Your Ref A/28/19/PL

Our Ref: NW/ARU/17/14E

### **RE Quiet Waters Roundstone Lane Angmering BN16 4AX**

Thank you for your correspondence of 8th March 2019 regarding the 'Variation of condition 1 imposed under A/81/18/RES relating to approved plans for site layout plan, apartment block floor plans, elevations & roof plans & materials layout' for which you seek advice from a crime prevention viewpoint.

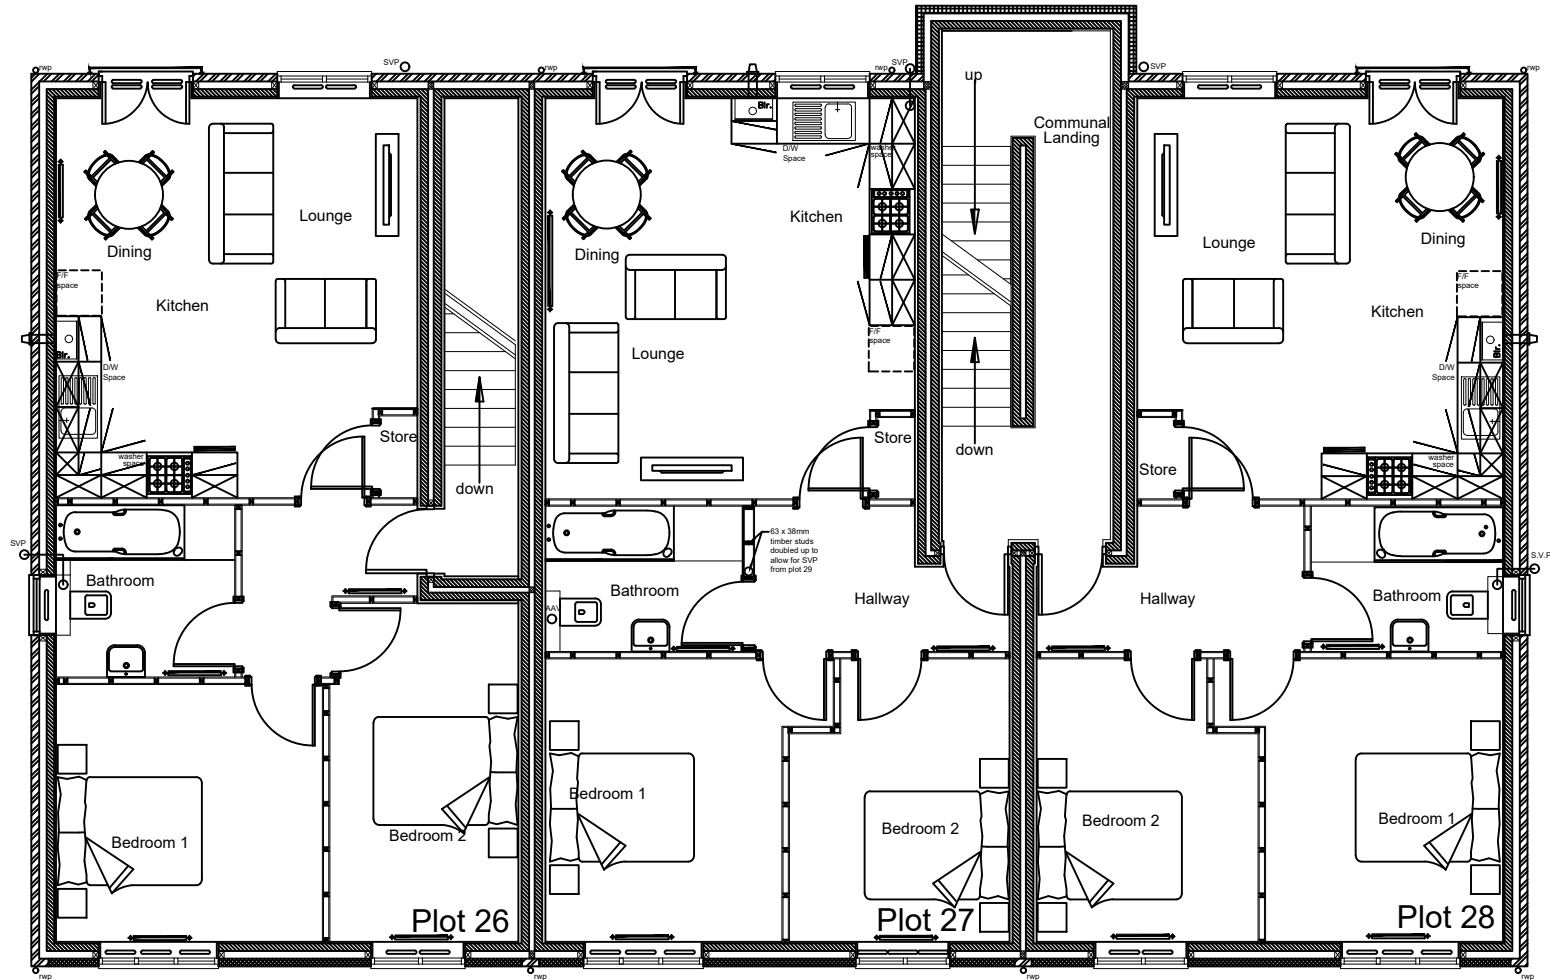
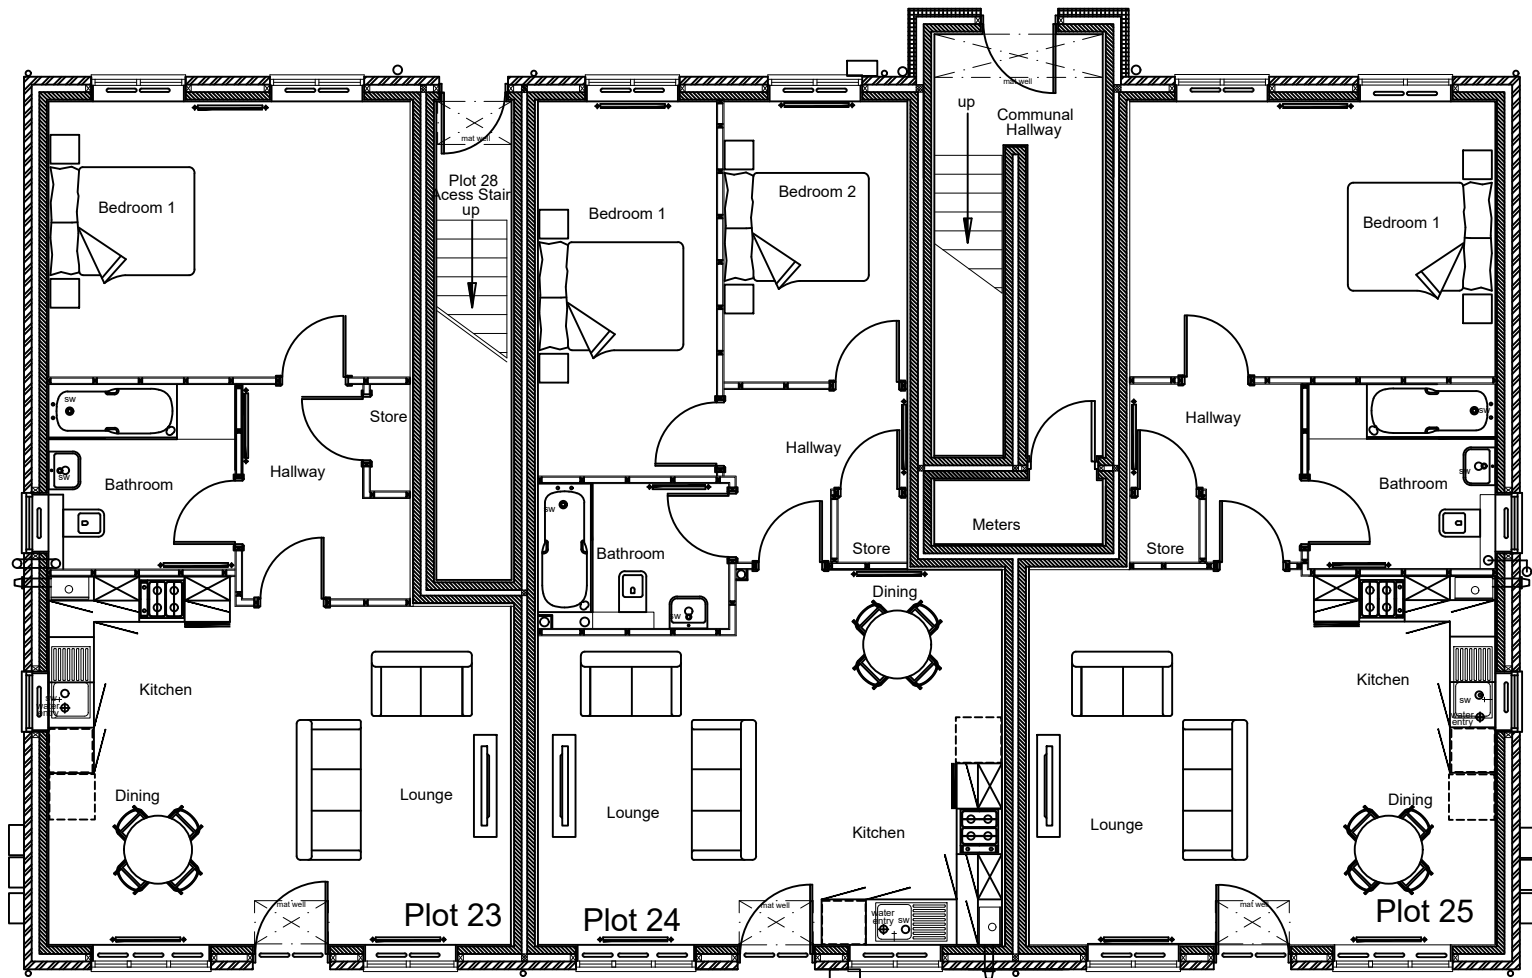
Lastly, I am pleased to see addition of a key pad lock fitted to the apartment building garden gate as it will improve the security for the residents and deter unauthorised access.

Project. Angmering		
Title. Proposed site Layout		
Construction		
Scales. 1:200@A1		Date. May 2018
Drawing Number. 1006-Ang101	Revision. R	Drawn by. PM

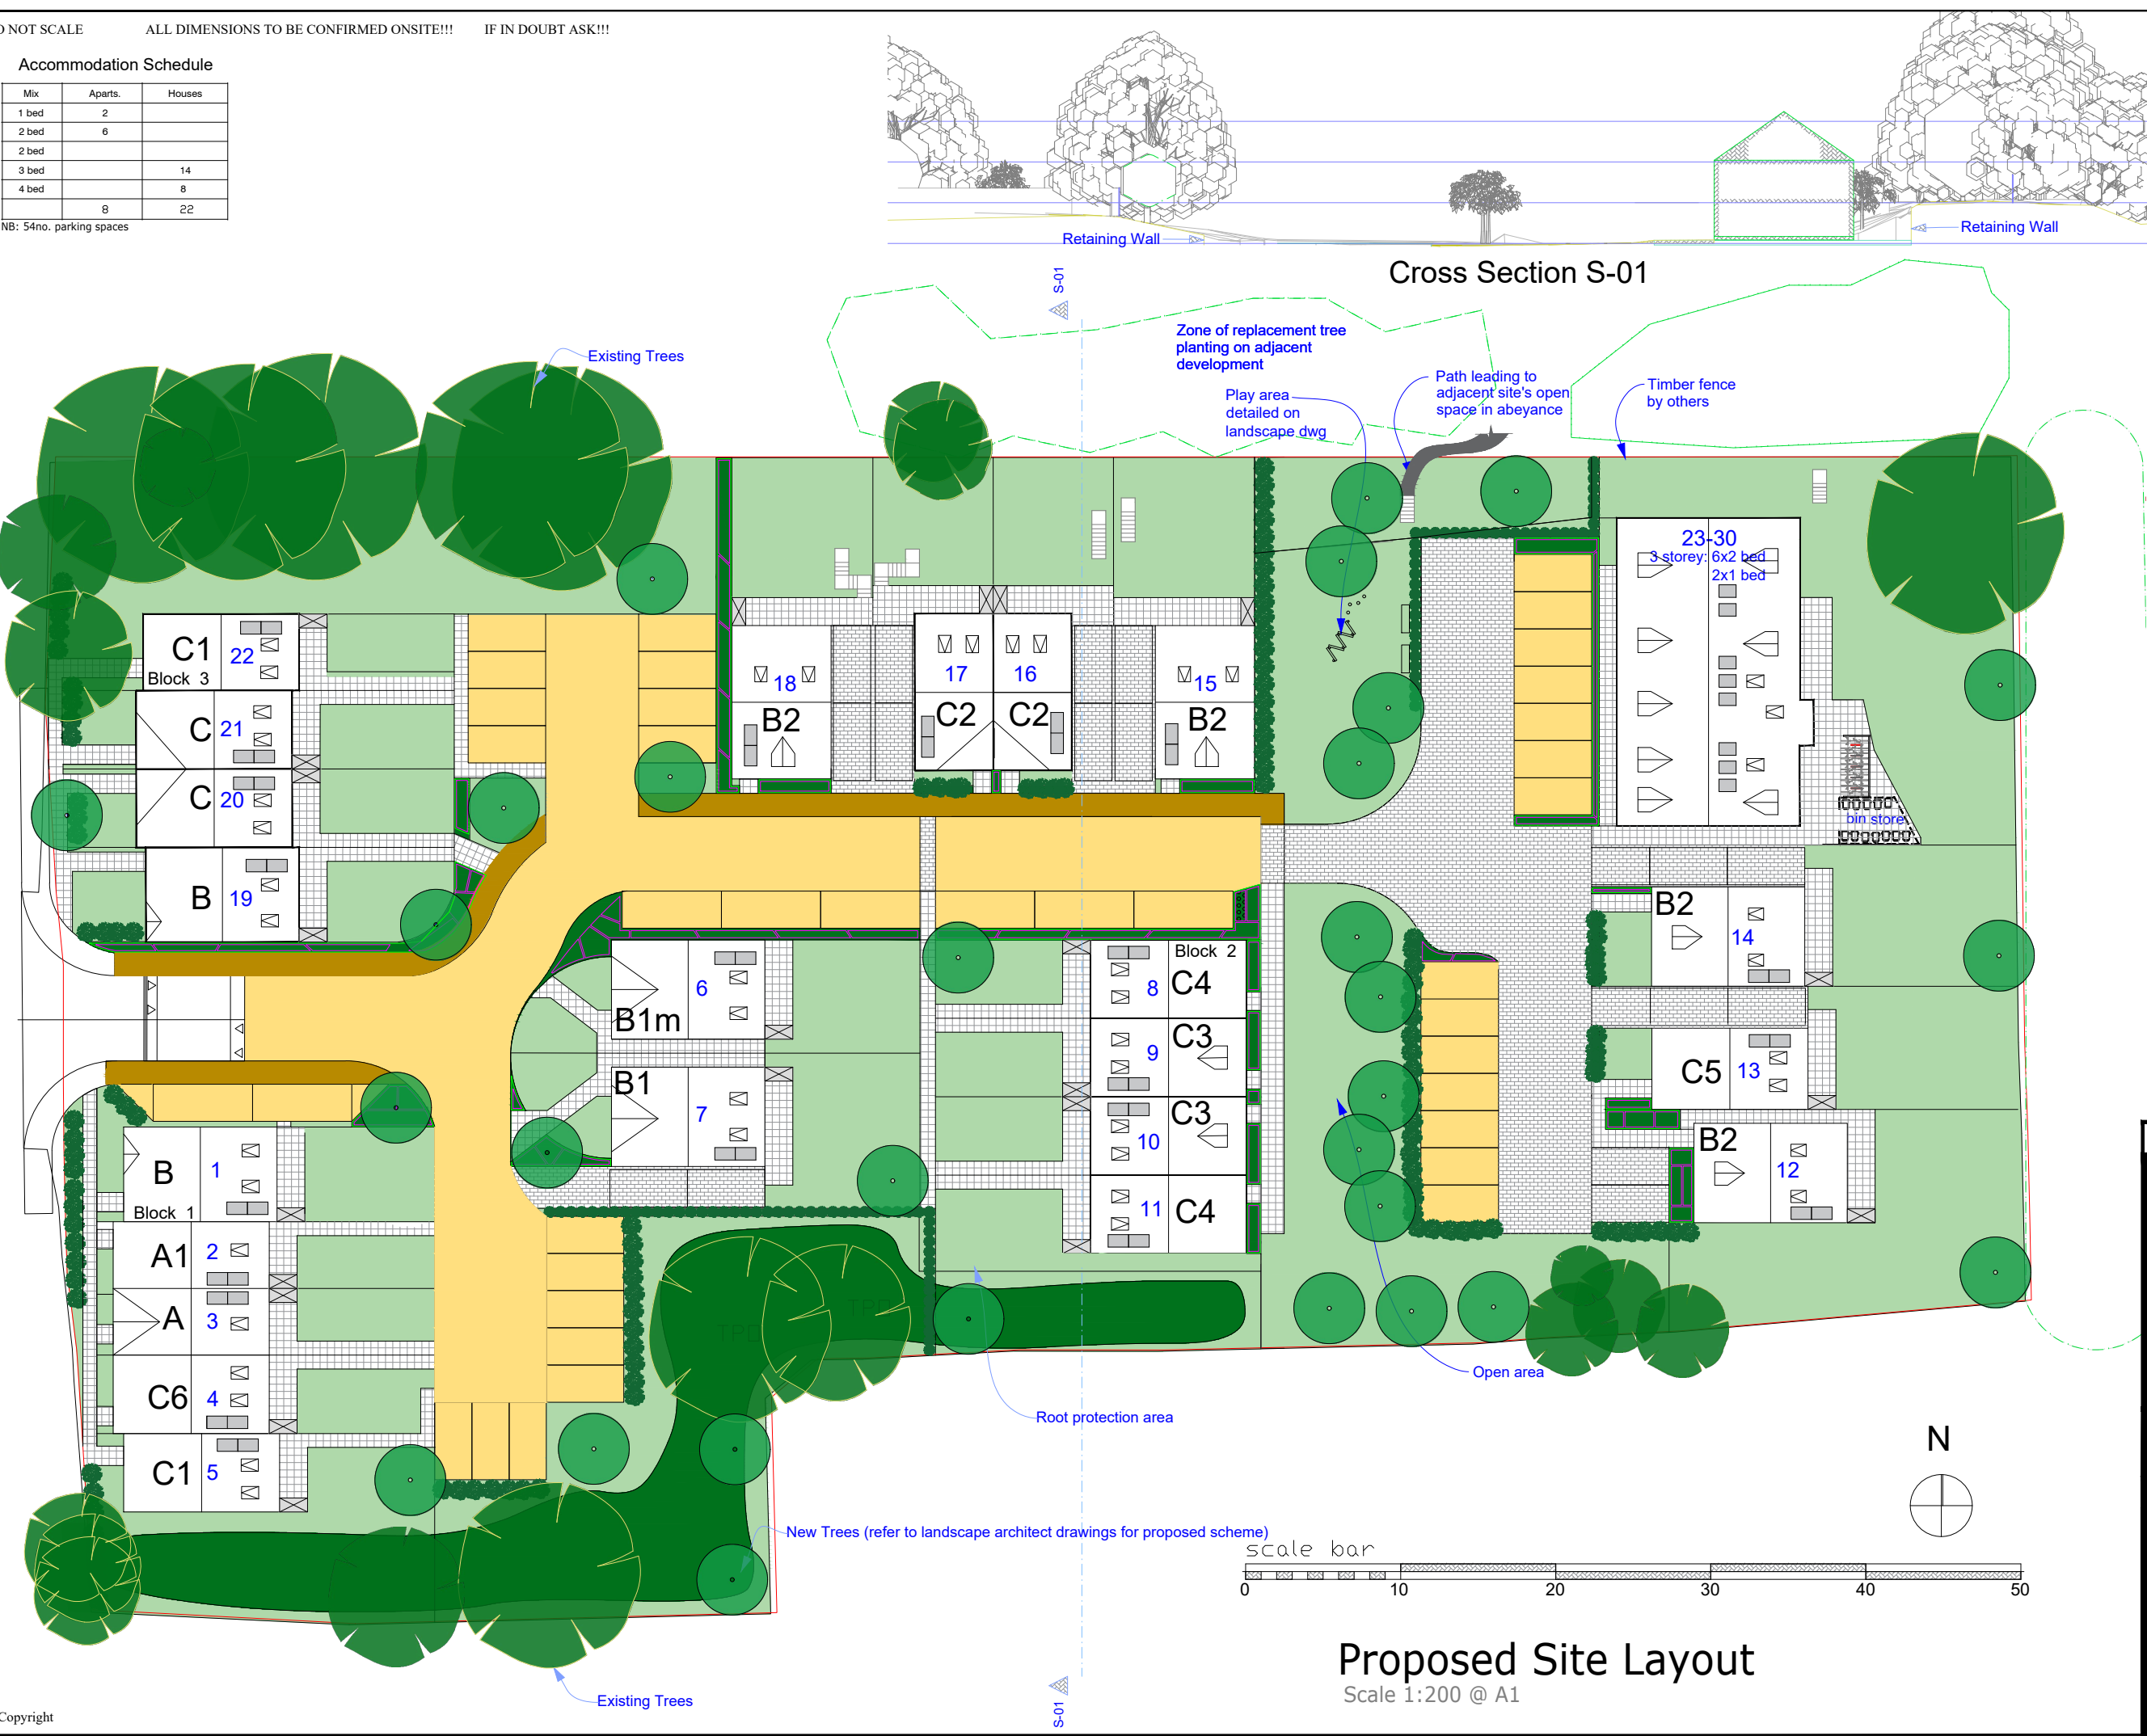
I would draw the applicants attention to my previous comments regarding the need for rear garden gate locks to be lockable from both sides. Gate locks that can be key locked from both sides would encourage residents to also lock the gate after leaving the back garden which they would be otherwise unable to do. This would then help deter potential offenders from reaching the rear house windows by providing an increased layer of security for each property. This would benefit plots 2,3,4,5 and 19 to 22 in particular as they all back on to rear parking areas.

I note 7 bollard lights are intended to be positioned at various points throughout the site for 'discreet' lighting.

Secured by Design 'Homes 2016' document recommends all street lighting should meet specifications within BS 5489:2013. It also comments that bollard lighting is not compliant with BS5489:2013 because it does not project sufficient light at the right height and distorts the available light due to the up lighting effect; making it difficult to recognize facial features and as a result causes an increase in fear of crime. Consideration should also be given to the location of trees and the effects of various seasons have to the lighting, as during the summer months foliage can seriously reduce the effects of the lighting.
